From: Andrew Strange <[REDACTED]>
Sent: 25 March 2019 18:54
To: Amber Willard
Subject: RE: BE/11/19/HH

I am the case officer on your application BE/11/19/HH at Parkside Farm, Shripney Road.

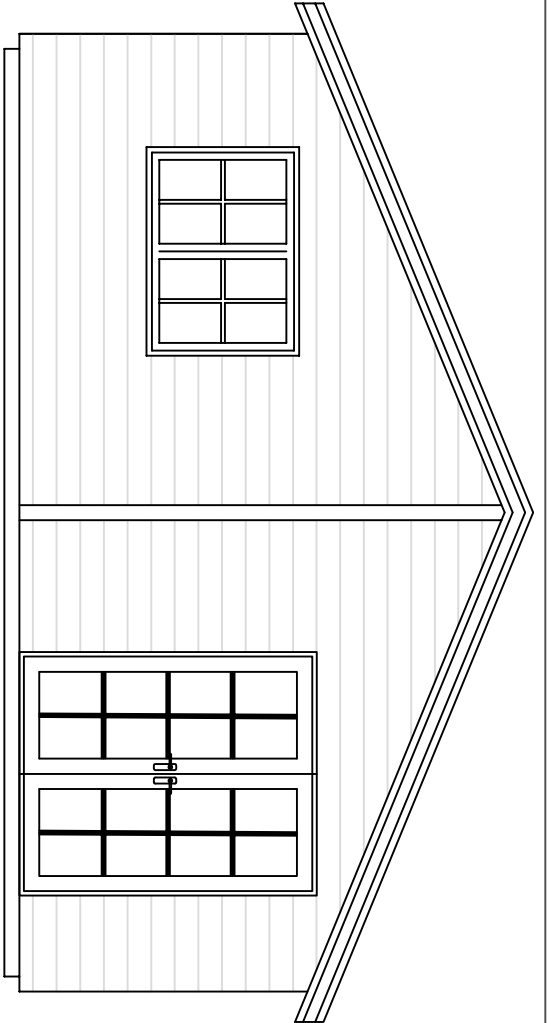
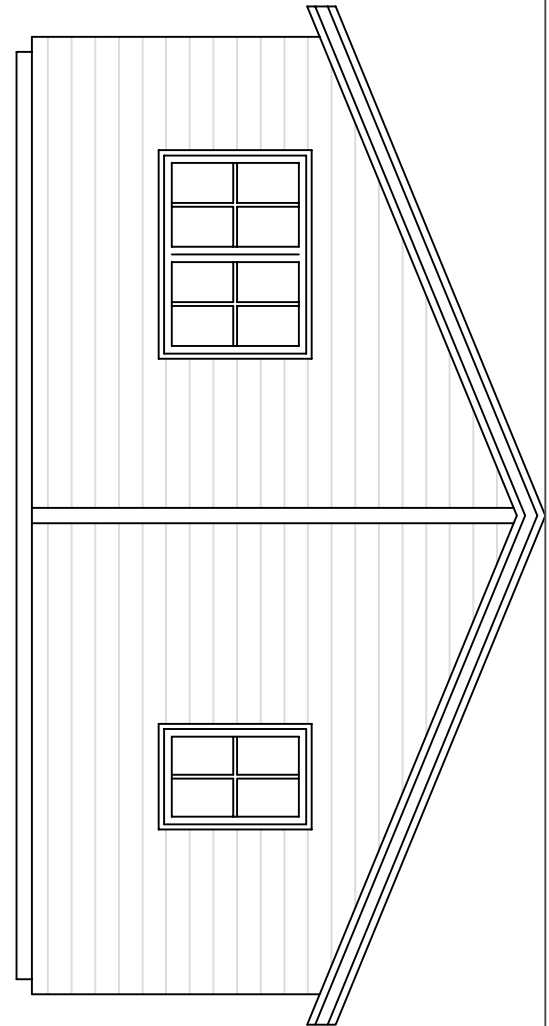
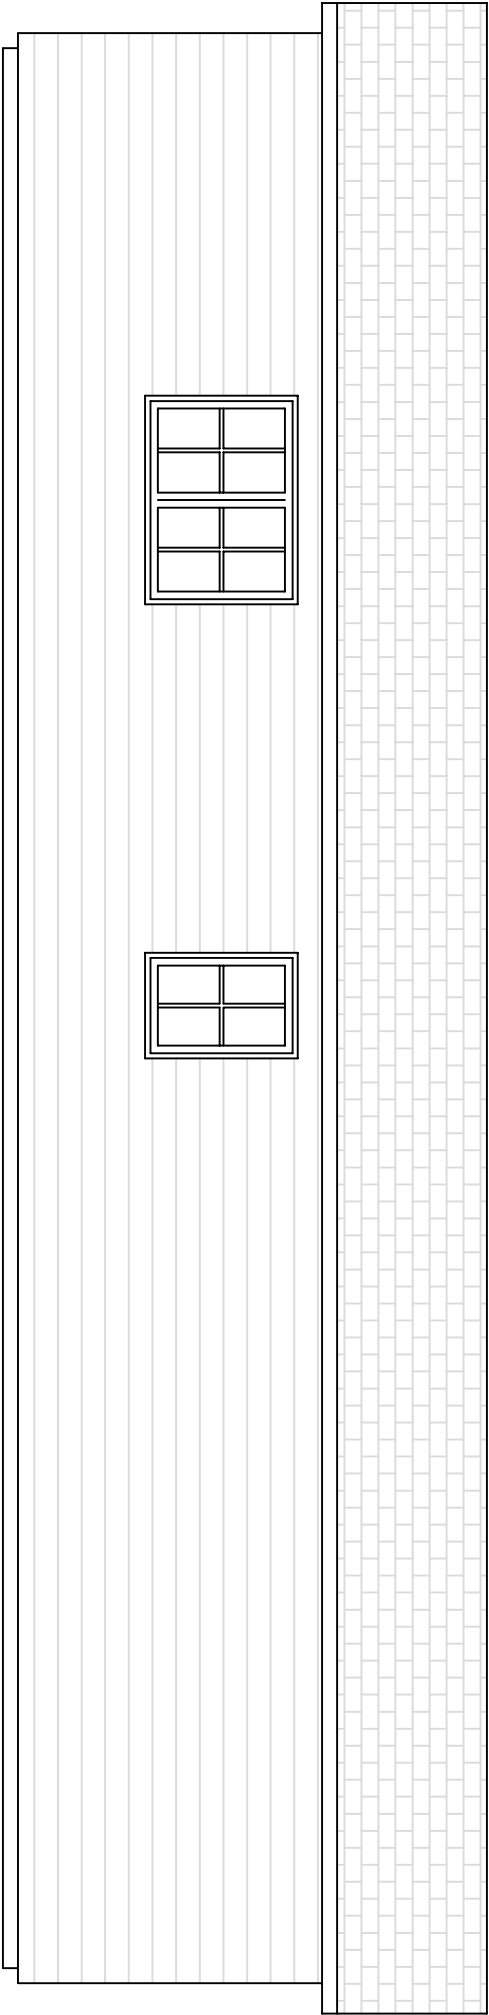
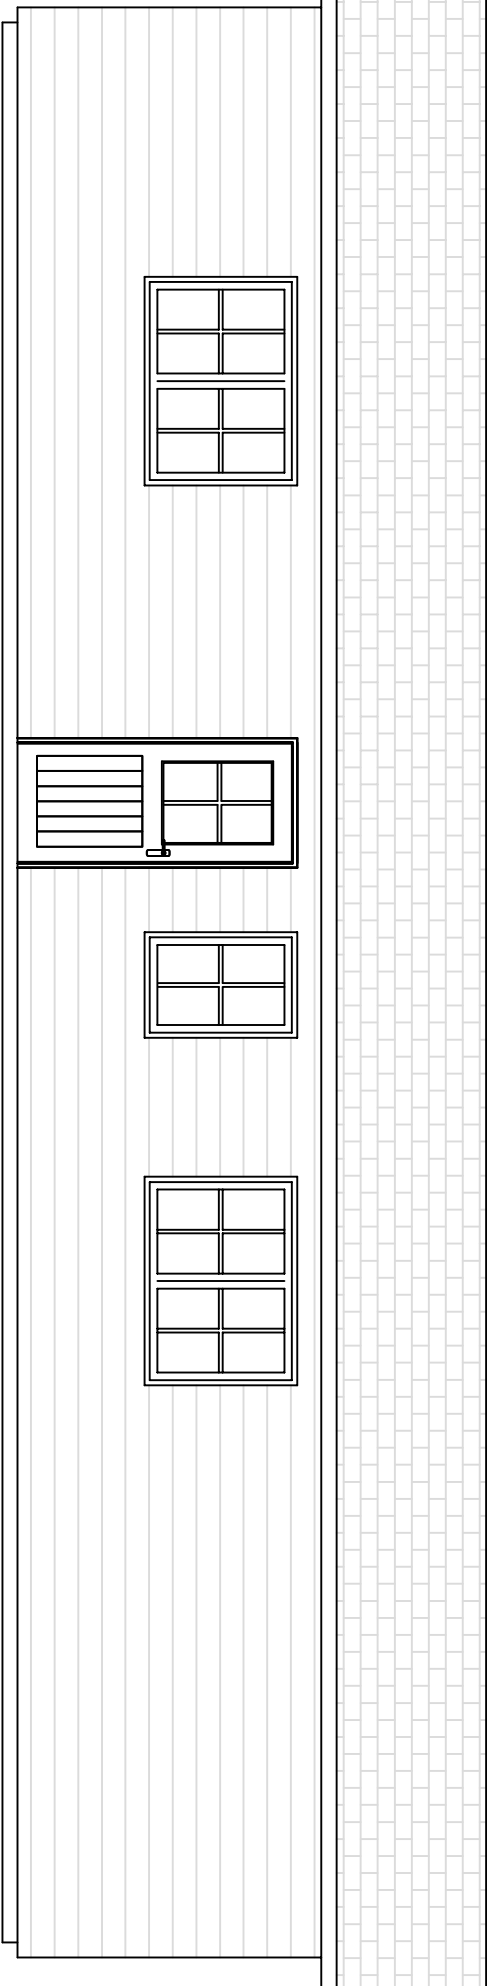
I am just writing to enquire as to what the proposed colour of the outbuilding is to be or whether it is to remain as existing (green).

If this has not yet been decided a condition may need to be included in which details are submitted at a later date however in order to avoid this an email confirming what the proposed colour is will be sufficient.

In answer to your question the colour will be a natural timber golden brown or similar.
